CITY OF ALBUQUERQUE

January 9, 2014

Re: **Temporary Certificate of Occupancy – Transportation Development**
Presbyterian Cooper Center, 9521 San Mateo NE
DRB Project Number 1007488
Traffic Engineer dated 7-25-12 (B17-D003)
Architect's Certification dated 1-7-14

ENLARGED GRADING PLAN
1" = 20'-0"

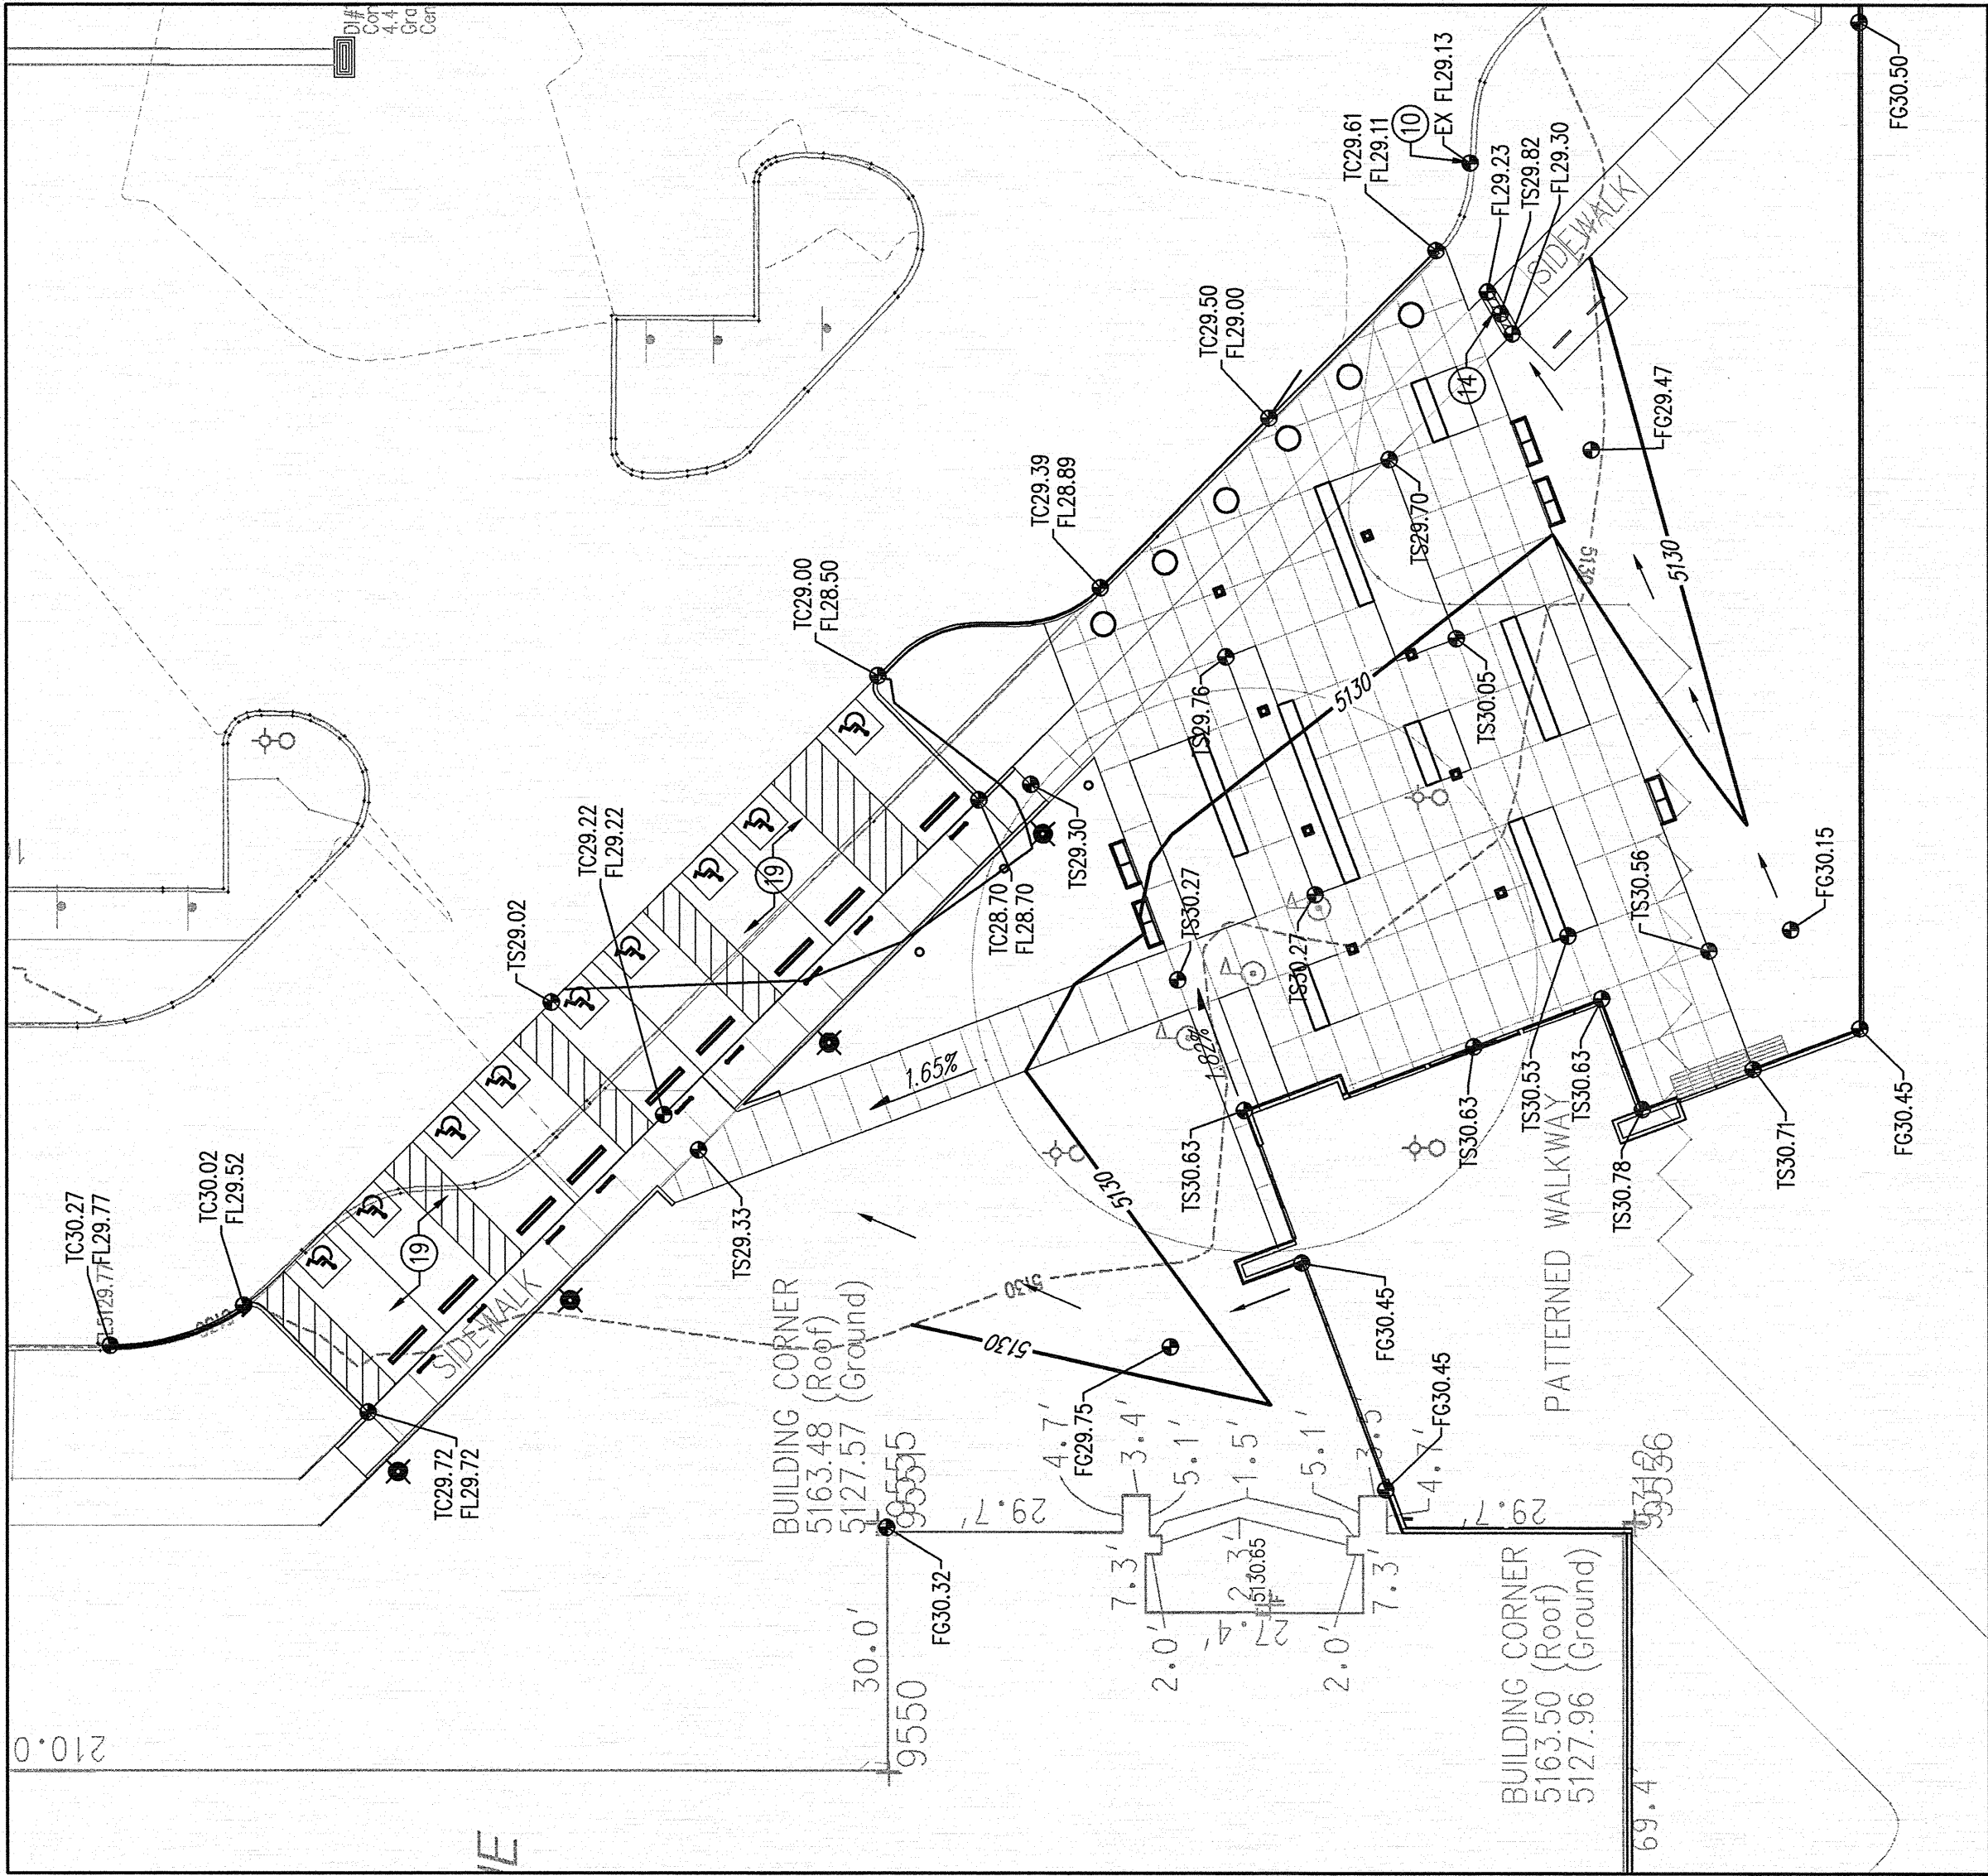
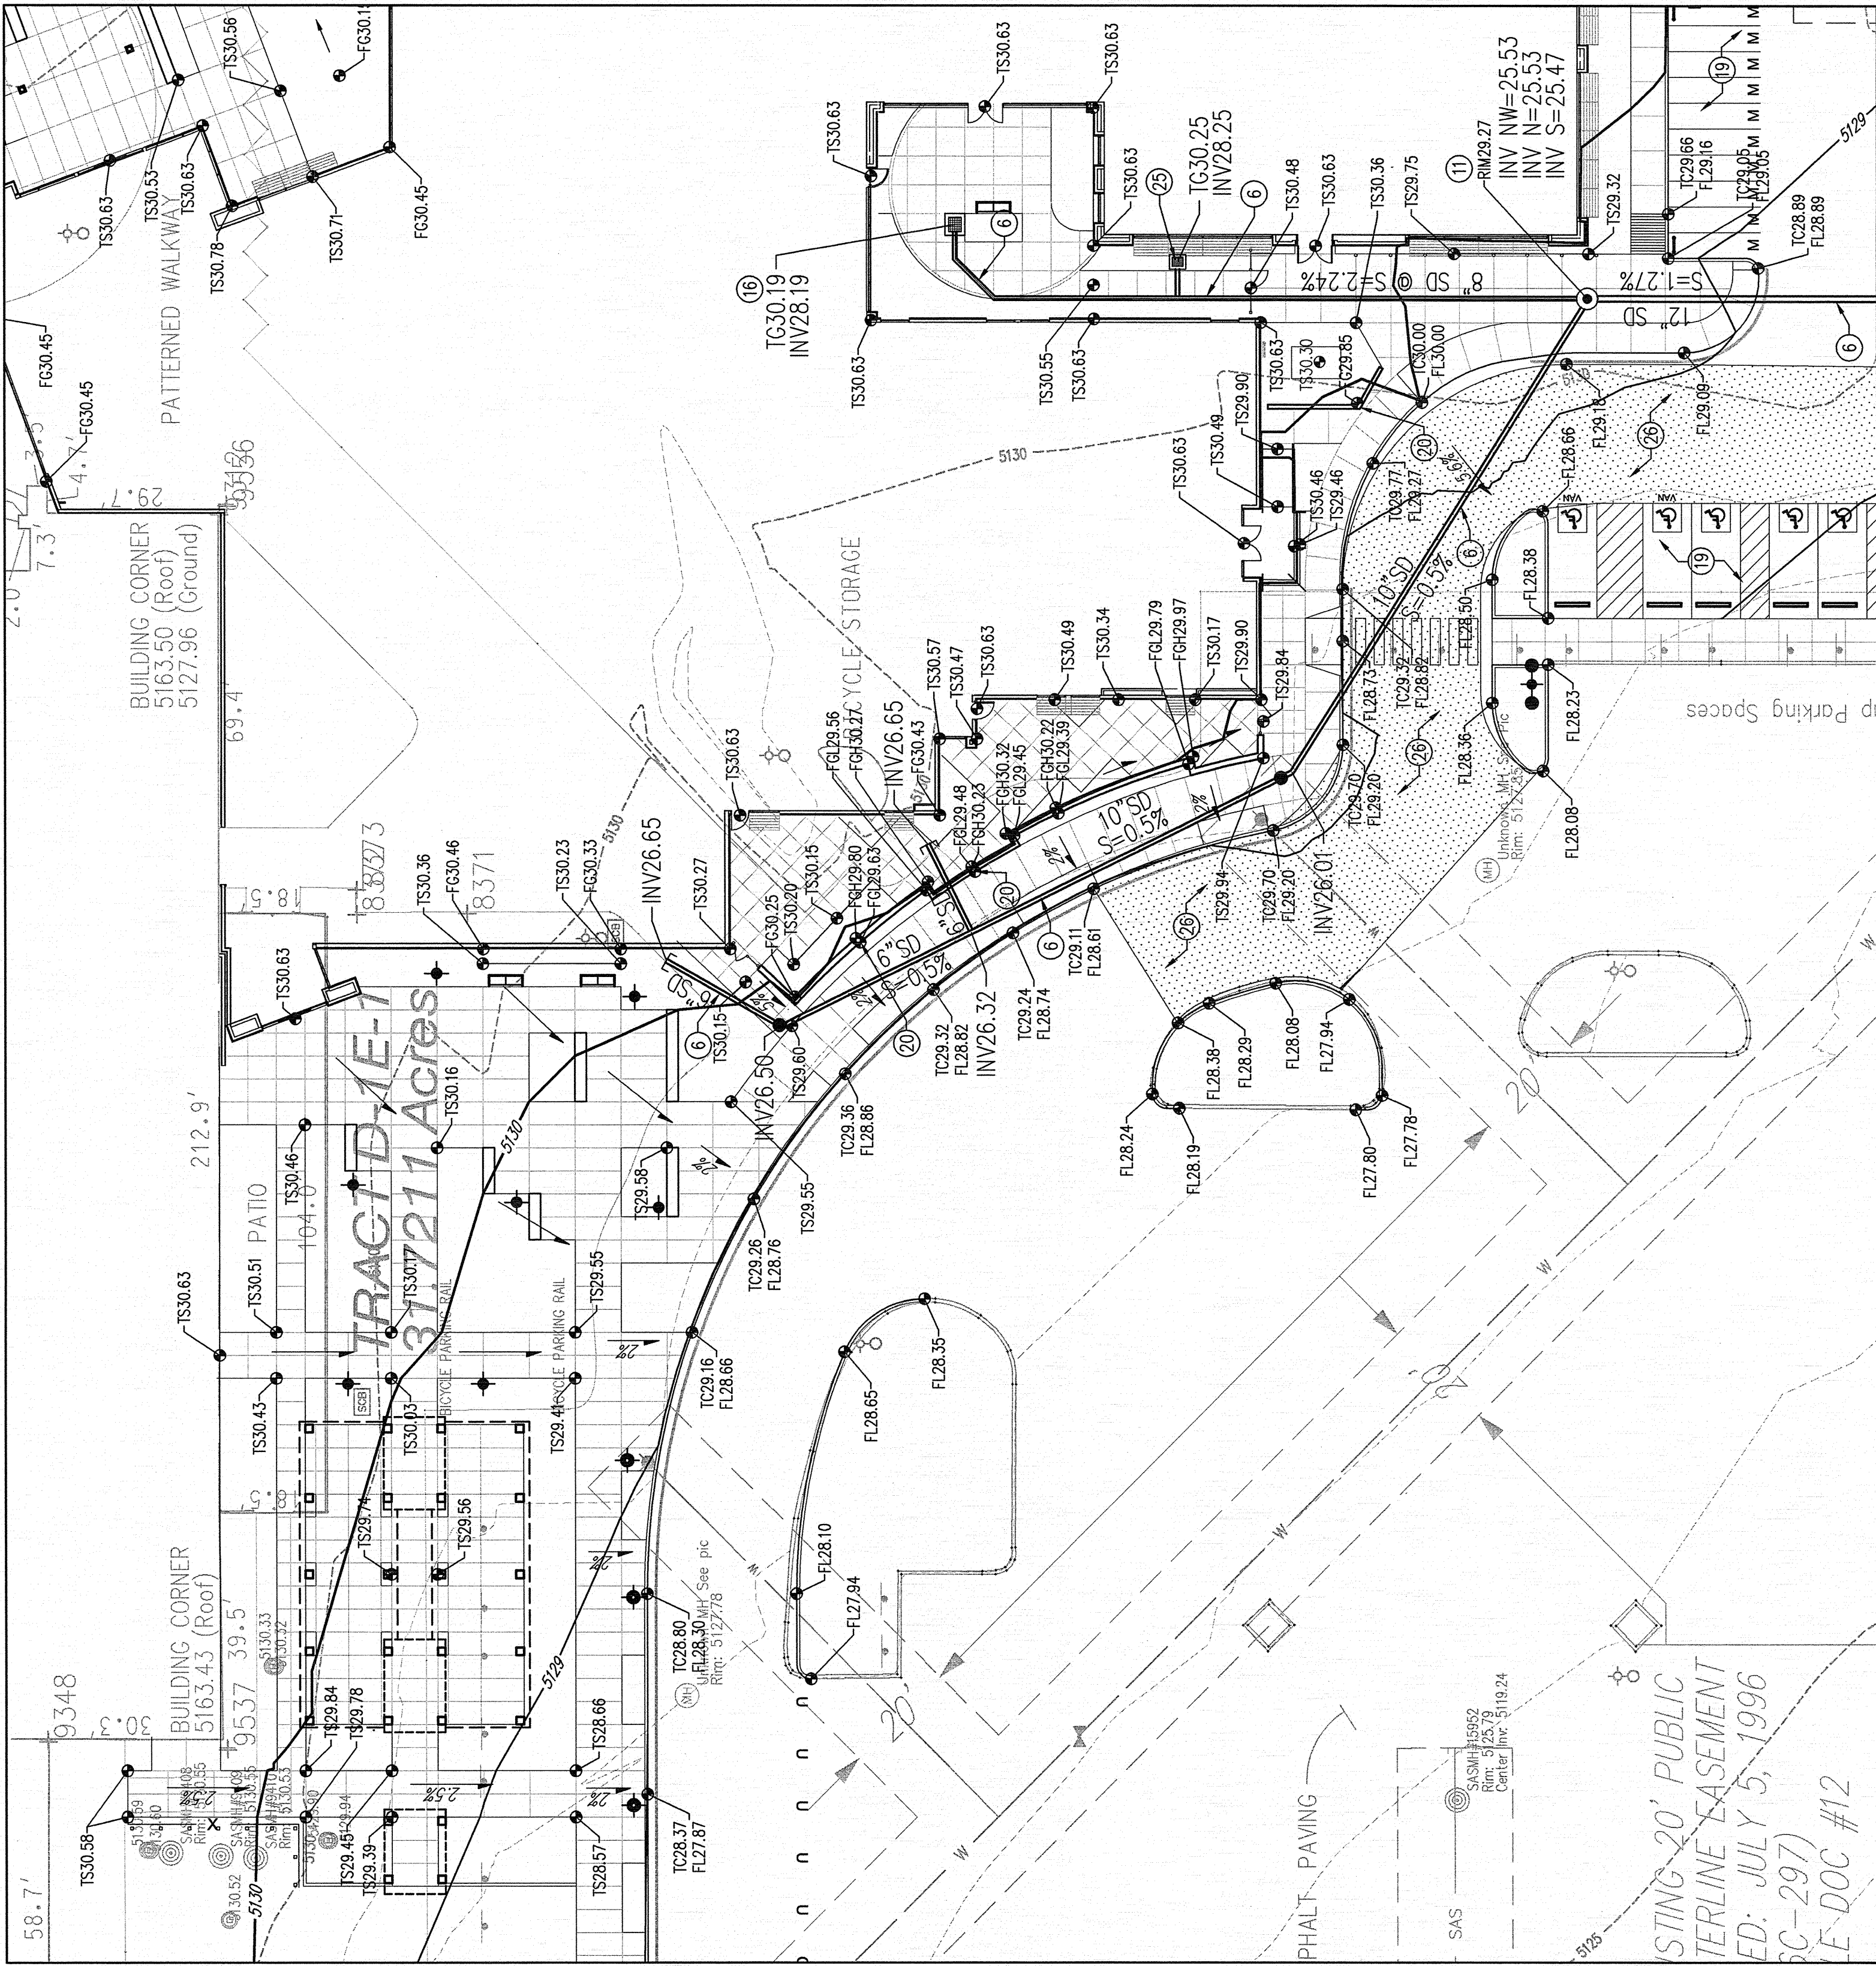
- Pedestrian crossings, Keyed Note 9 and 27, are not build to site plan notes.
